# V1\_Soils & Geology Report review 1.pdf Markup Summary

PCD No SP-23-009

JOB NO.  
212381  
**FIG. 3**

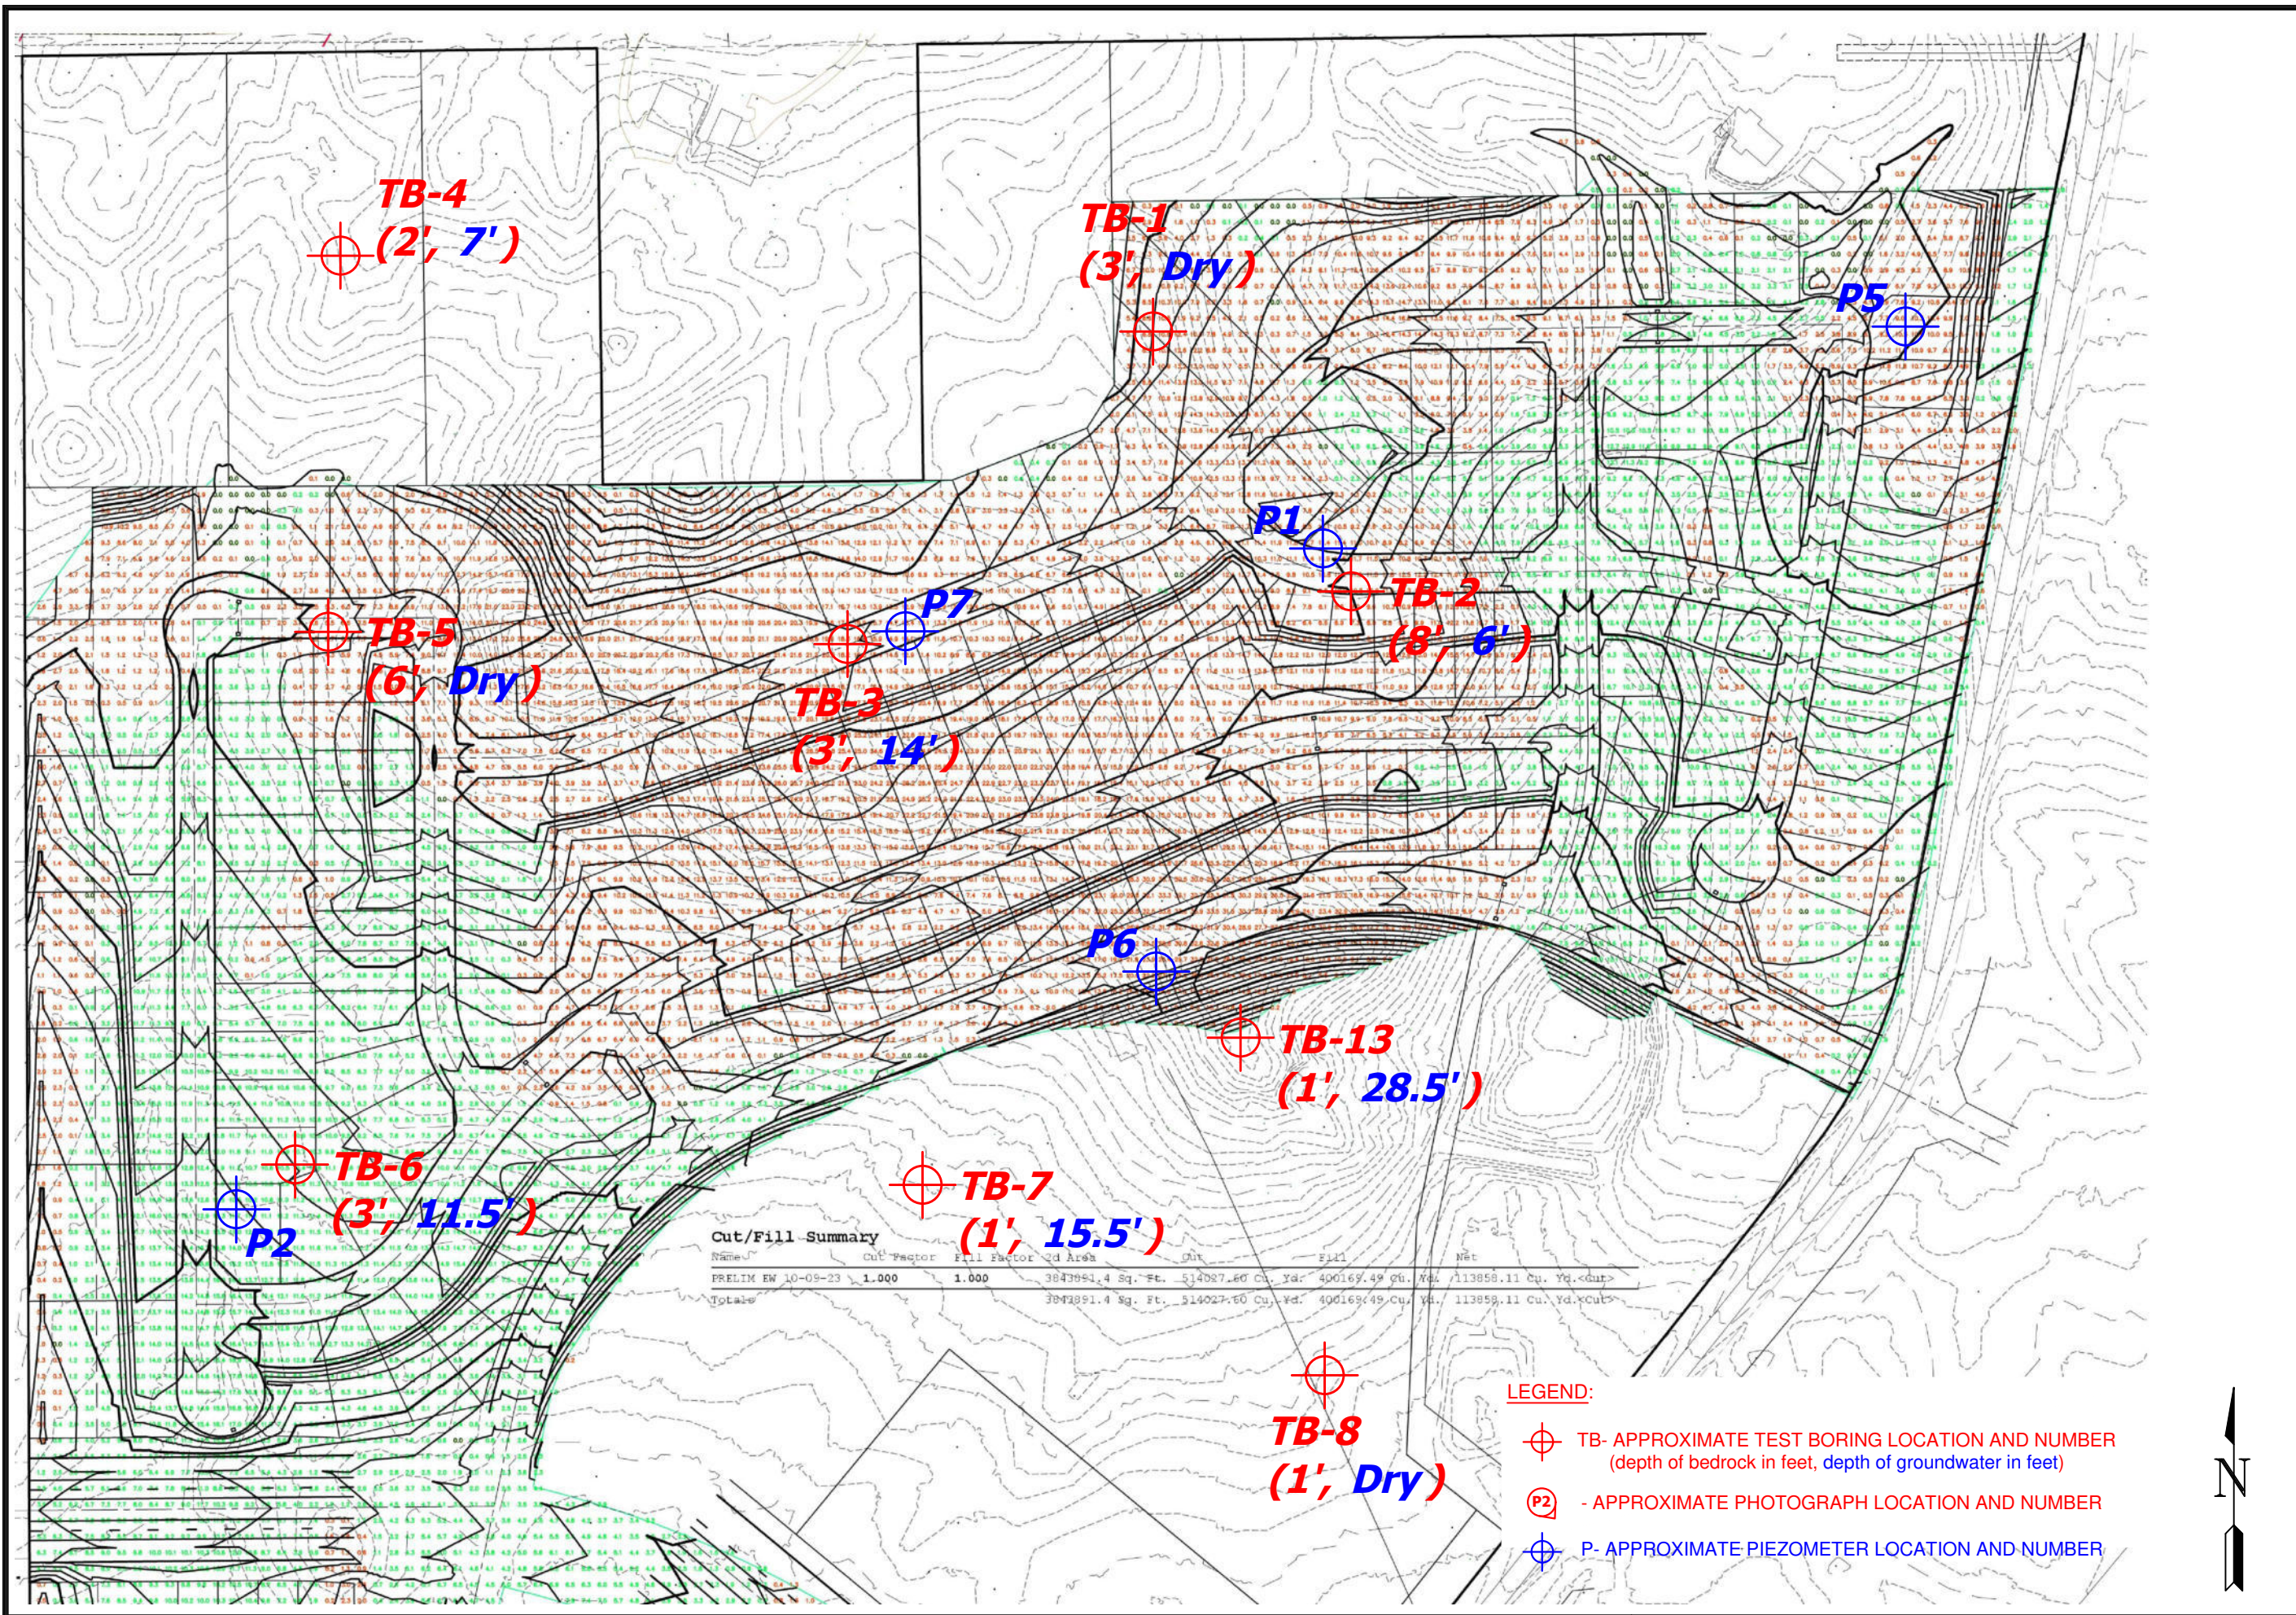
preparing this report. The locations of the test boring locations are shown in Figure 3. Recently installed temporary piezometers (P-1 - P-4) were placed in the vicinity of the test boring locations. The locations of the test boring locations are shown in Figure 3. The Summary of Laboratory Testing in Appendix B. Results of the testing will be provided in the final report.

Reference the section where additional information regarding the piezometers is located.

JOB NO.  
212381  
**FIG. 4**

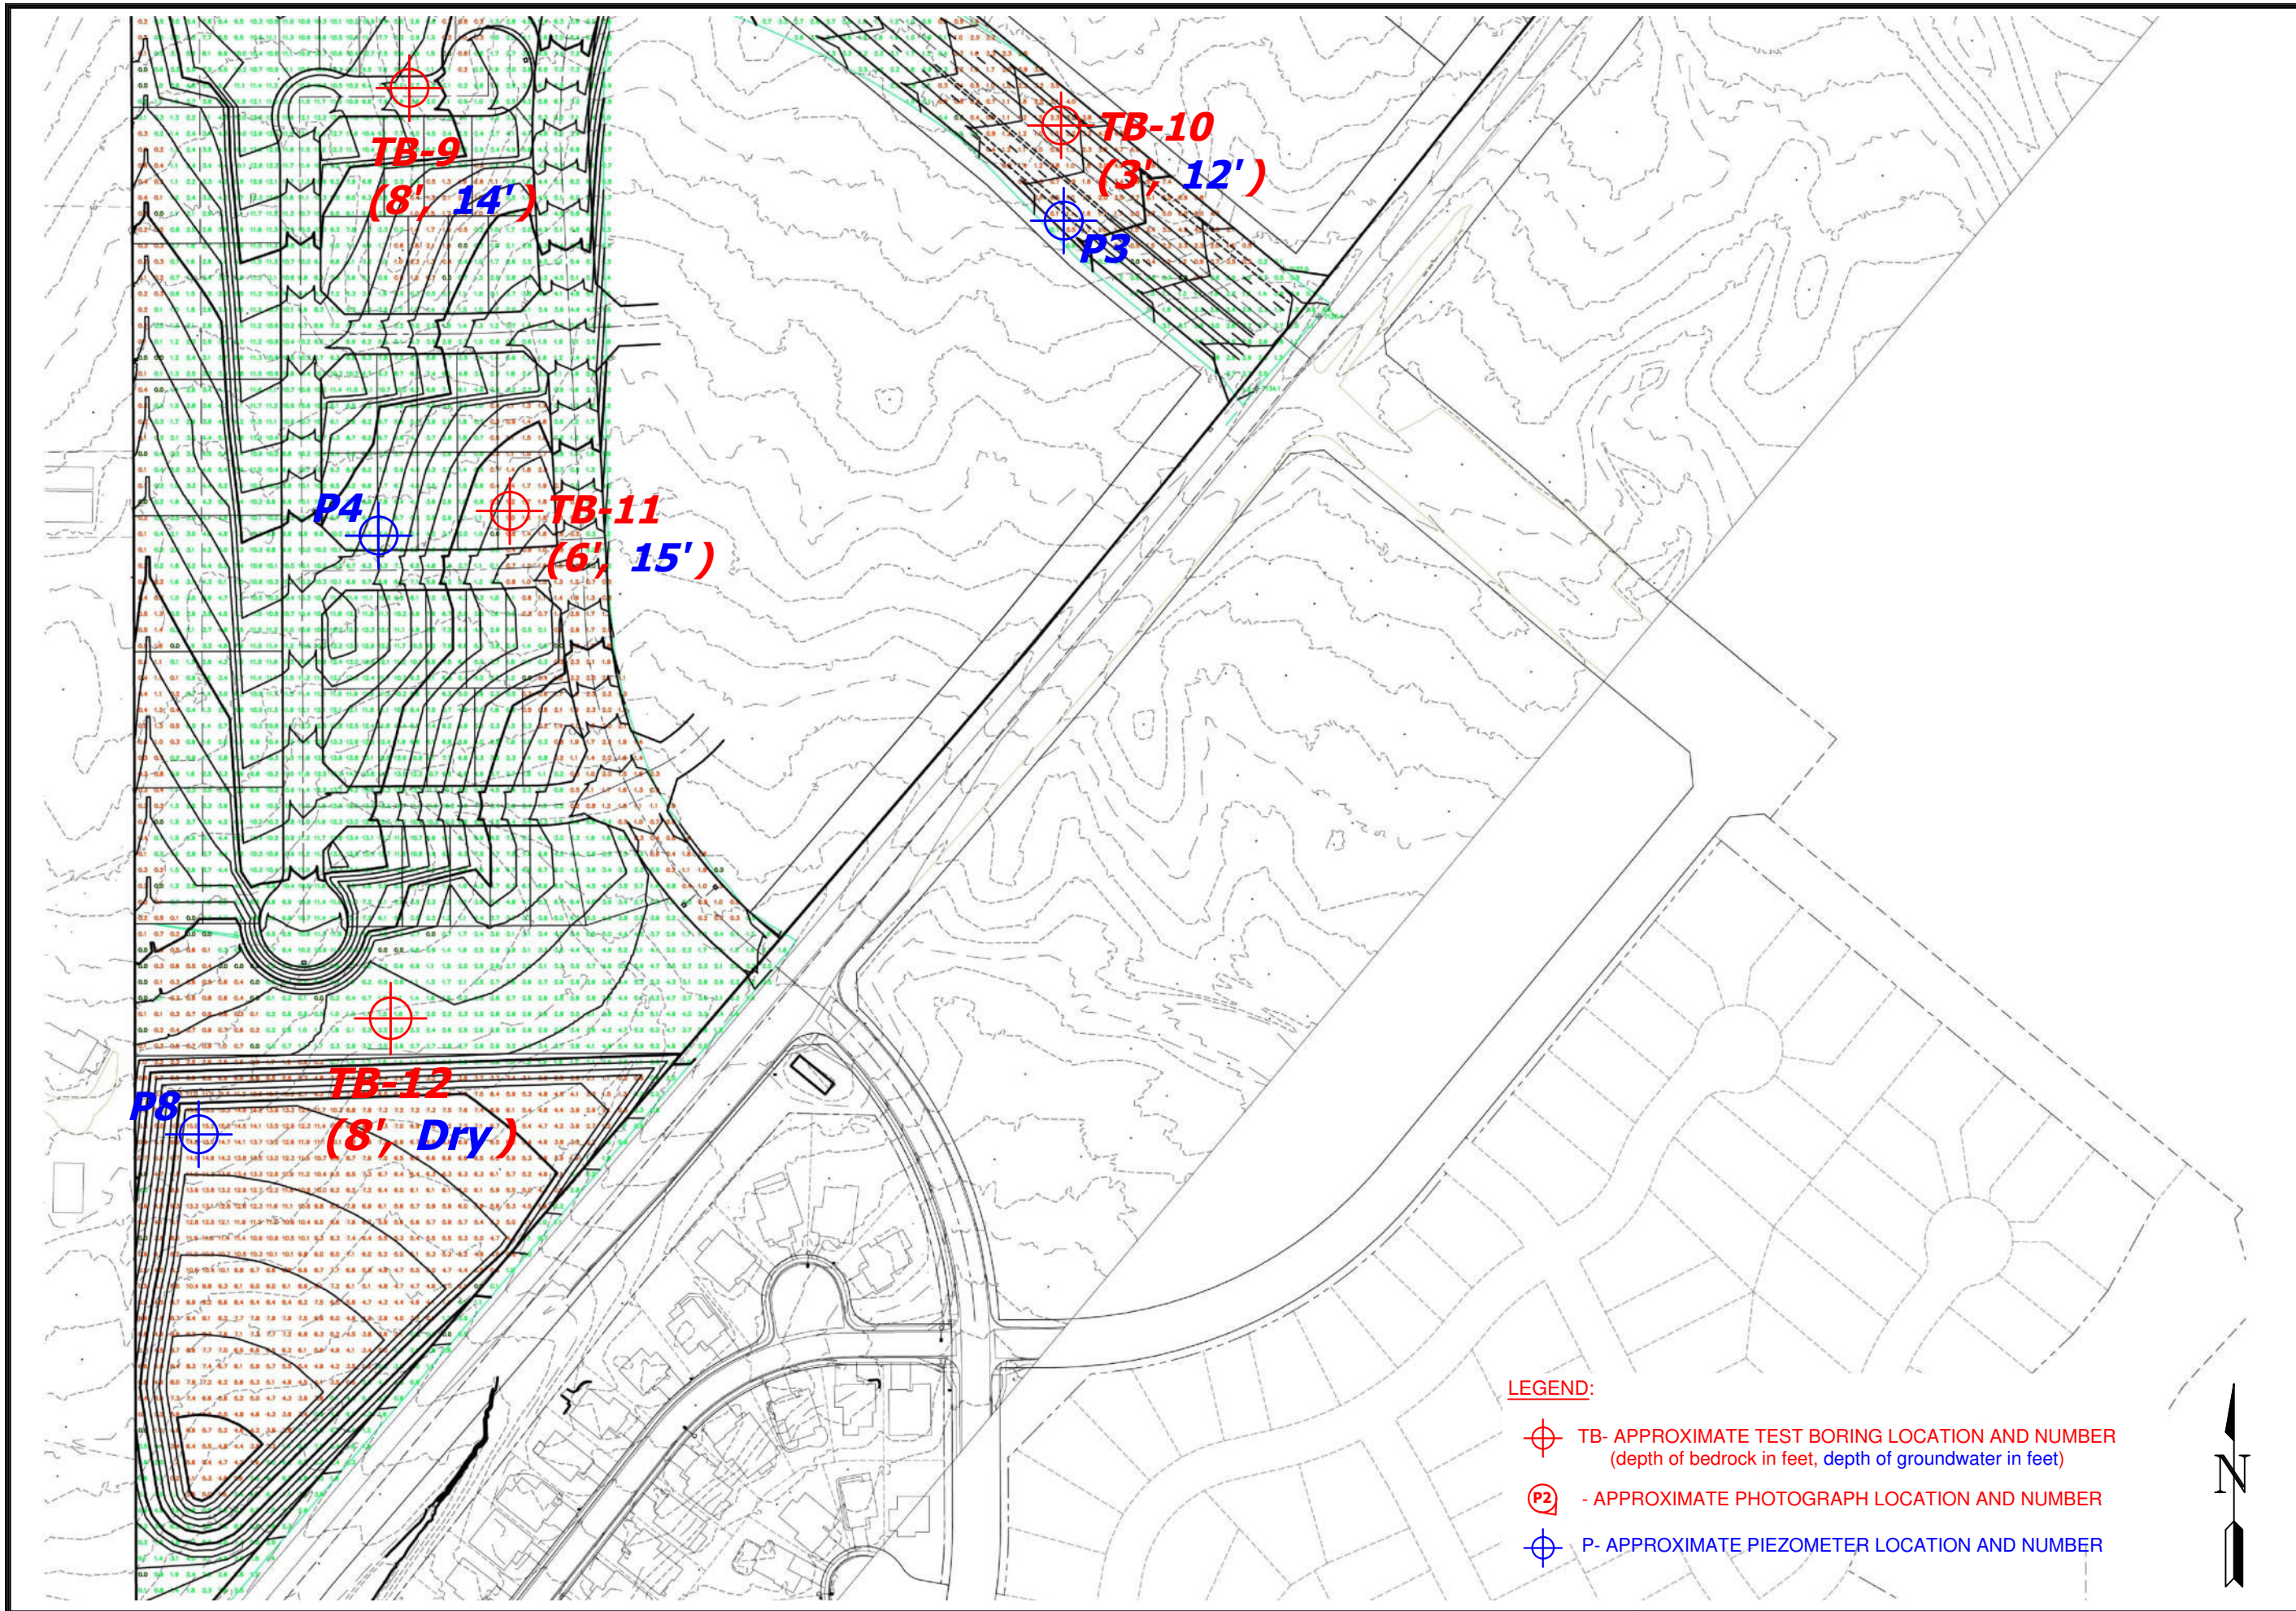
Per the grading plan provided, there appear to be major cuts on the site, ones which would fall within this range of groundwater. Provide discussion on how this will be dealt with.
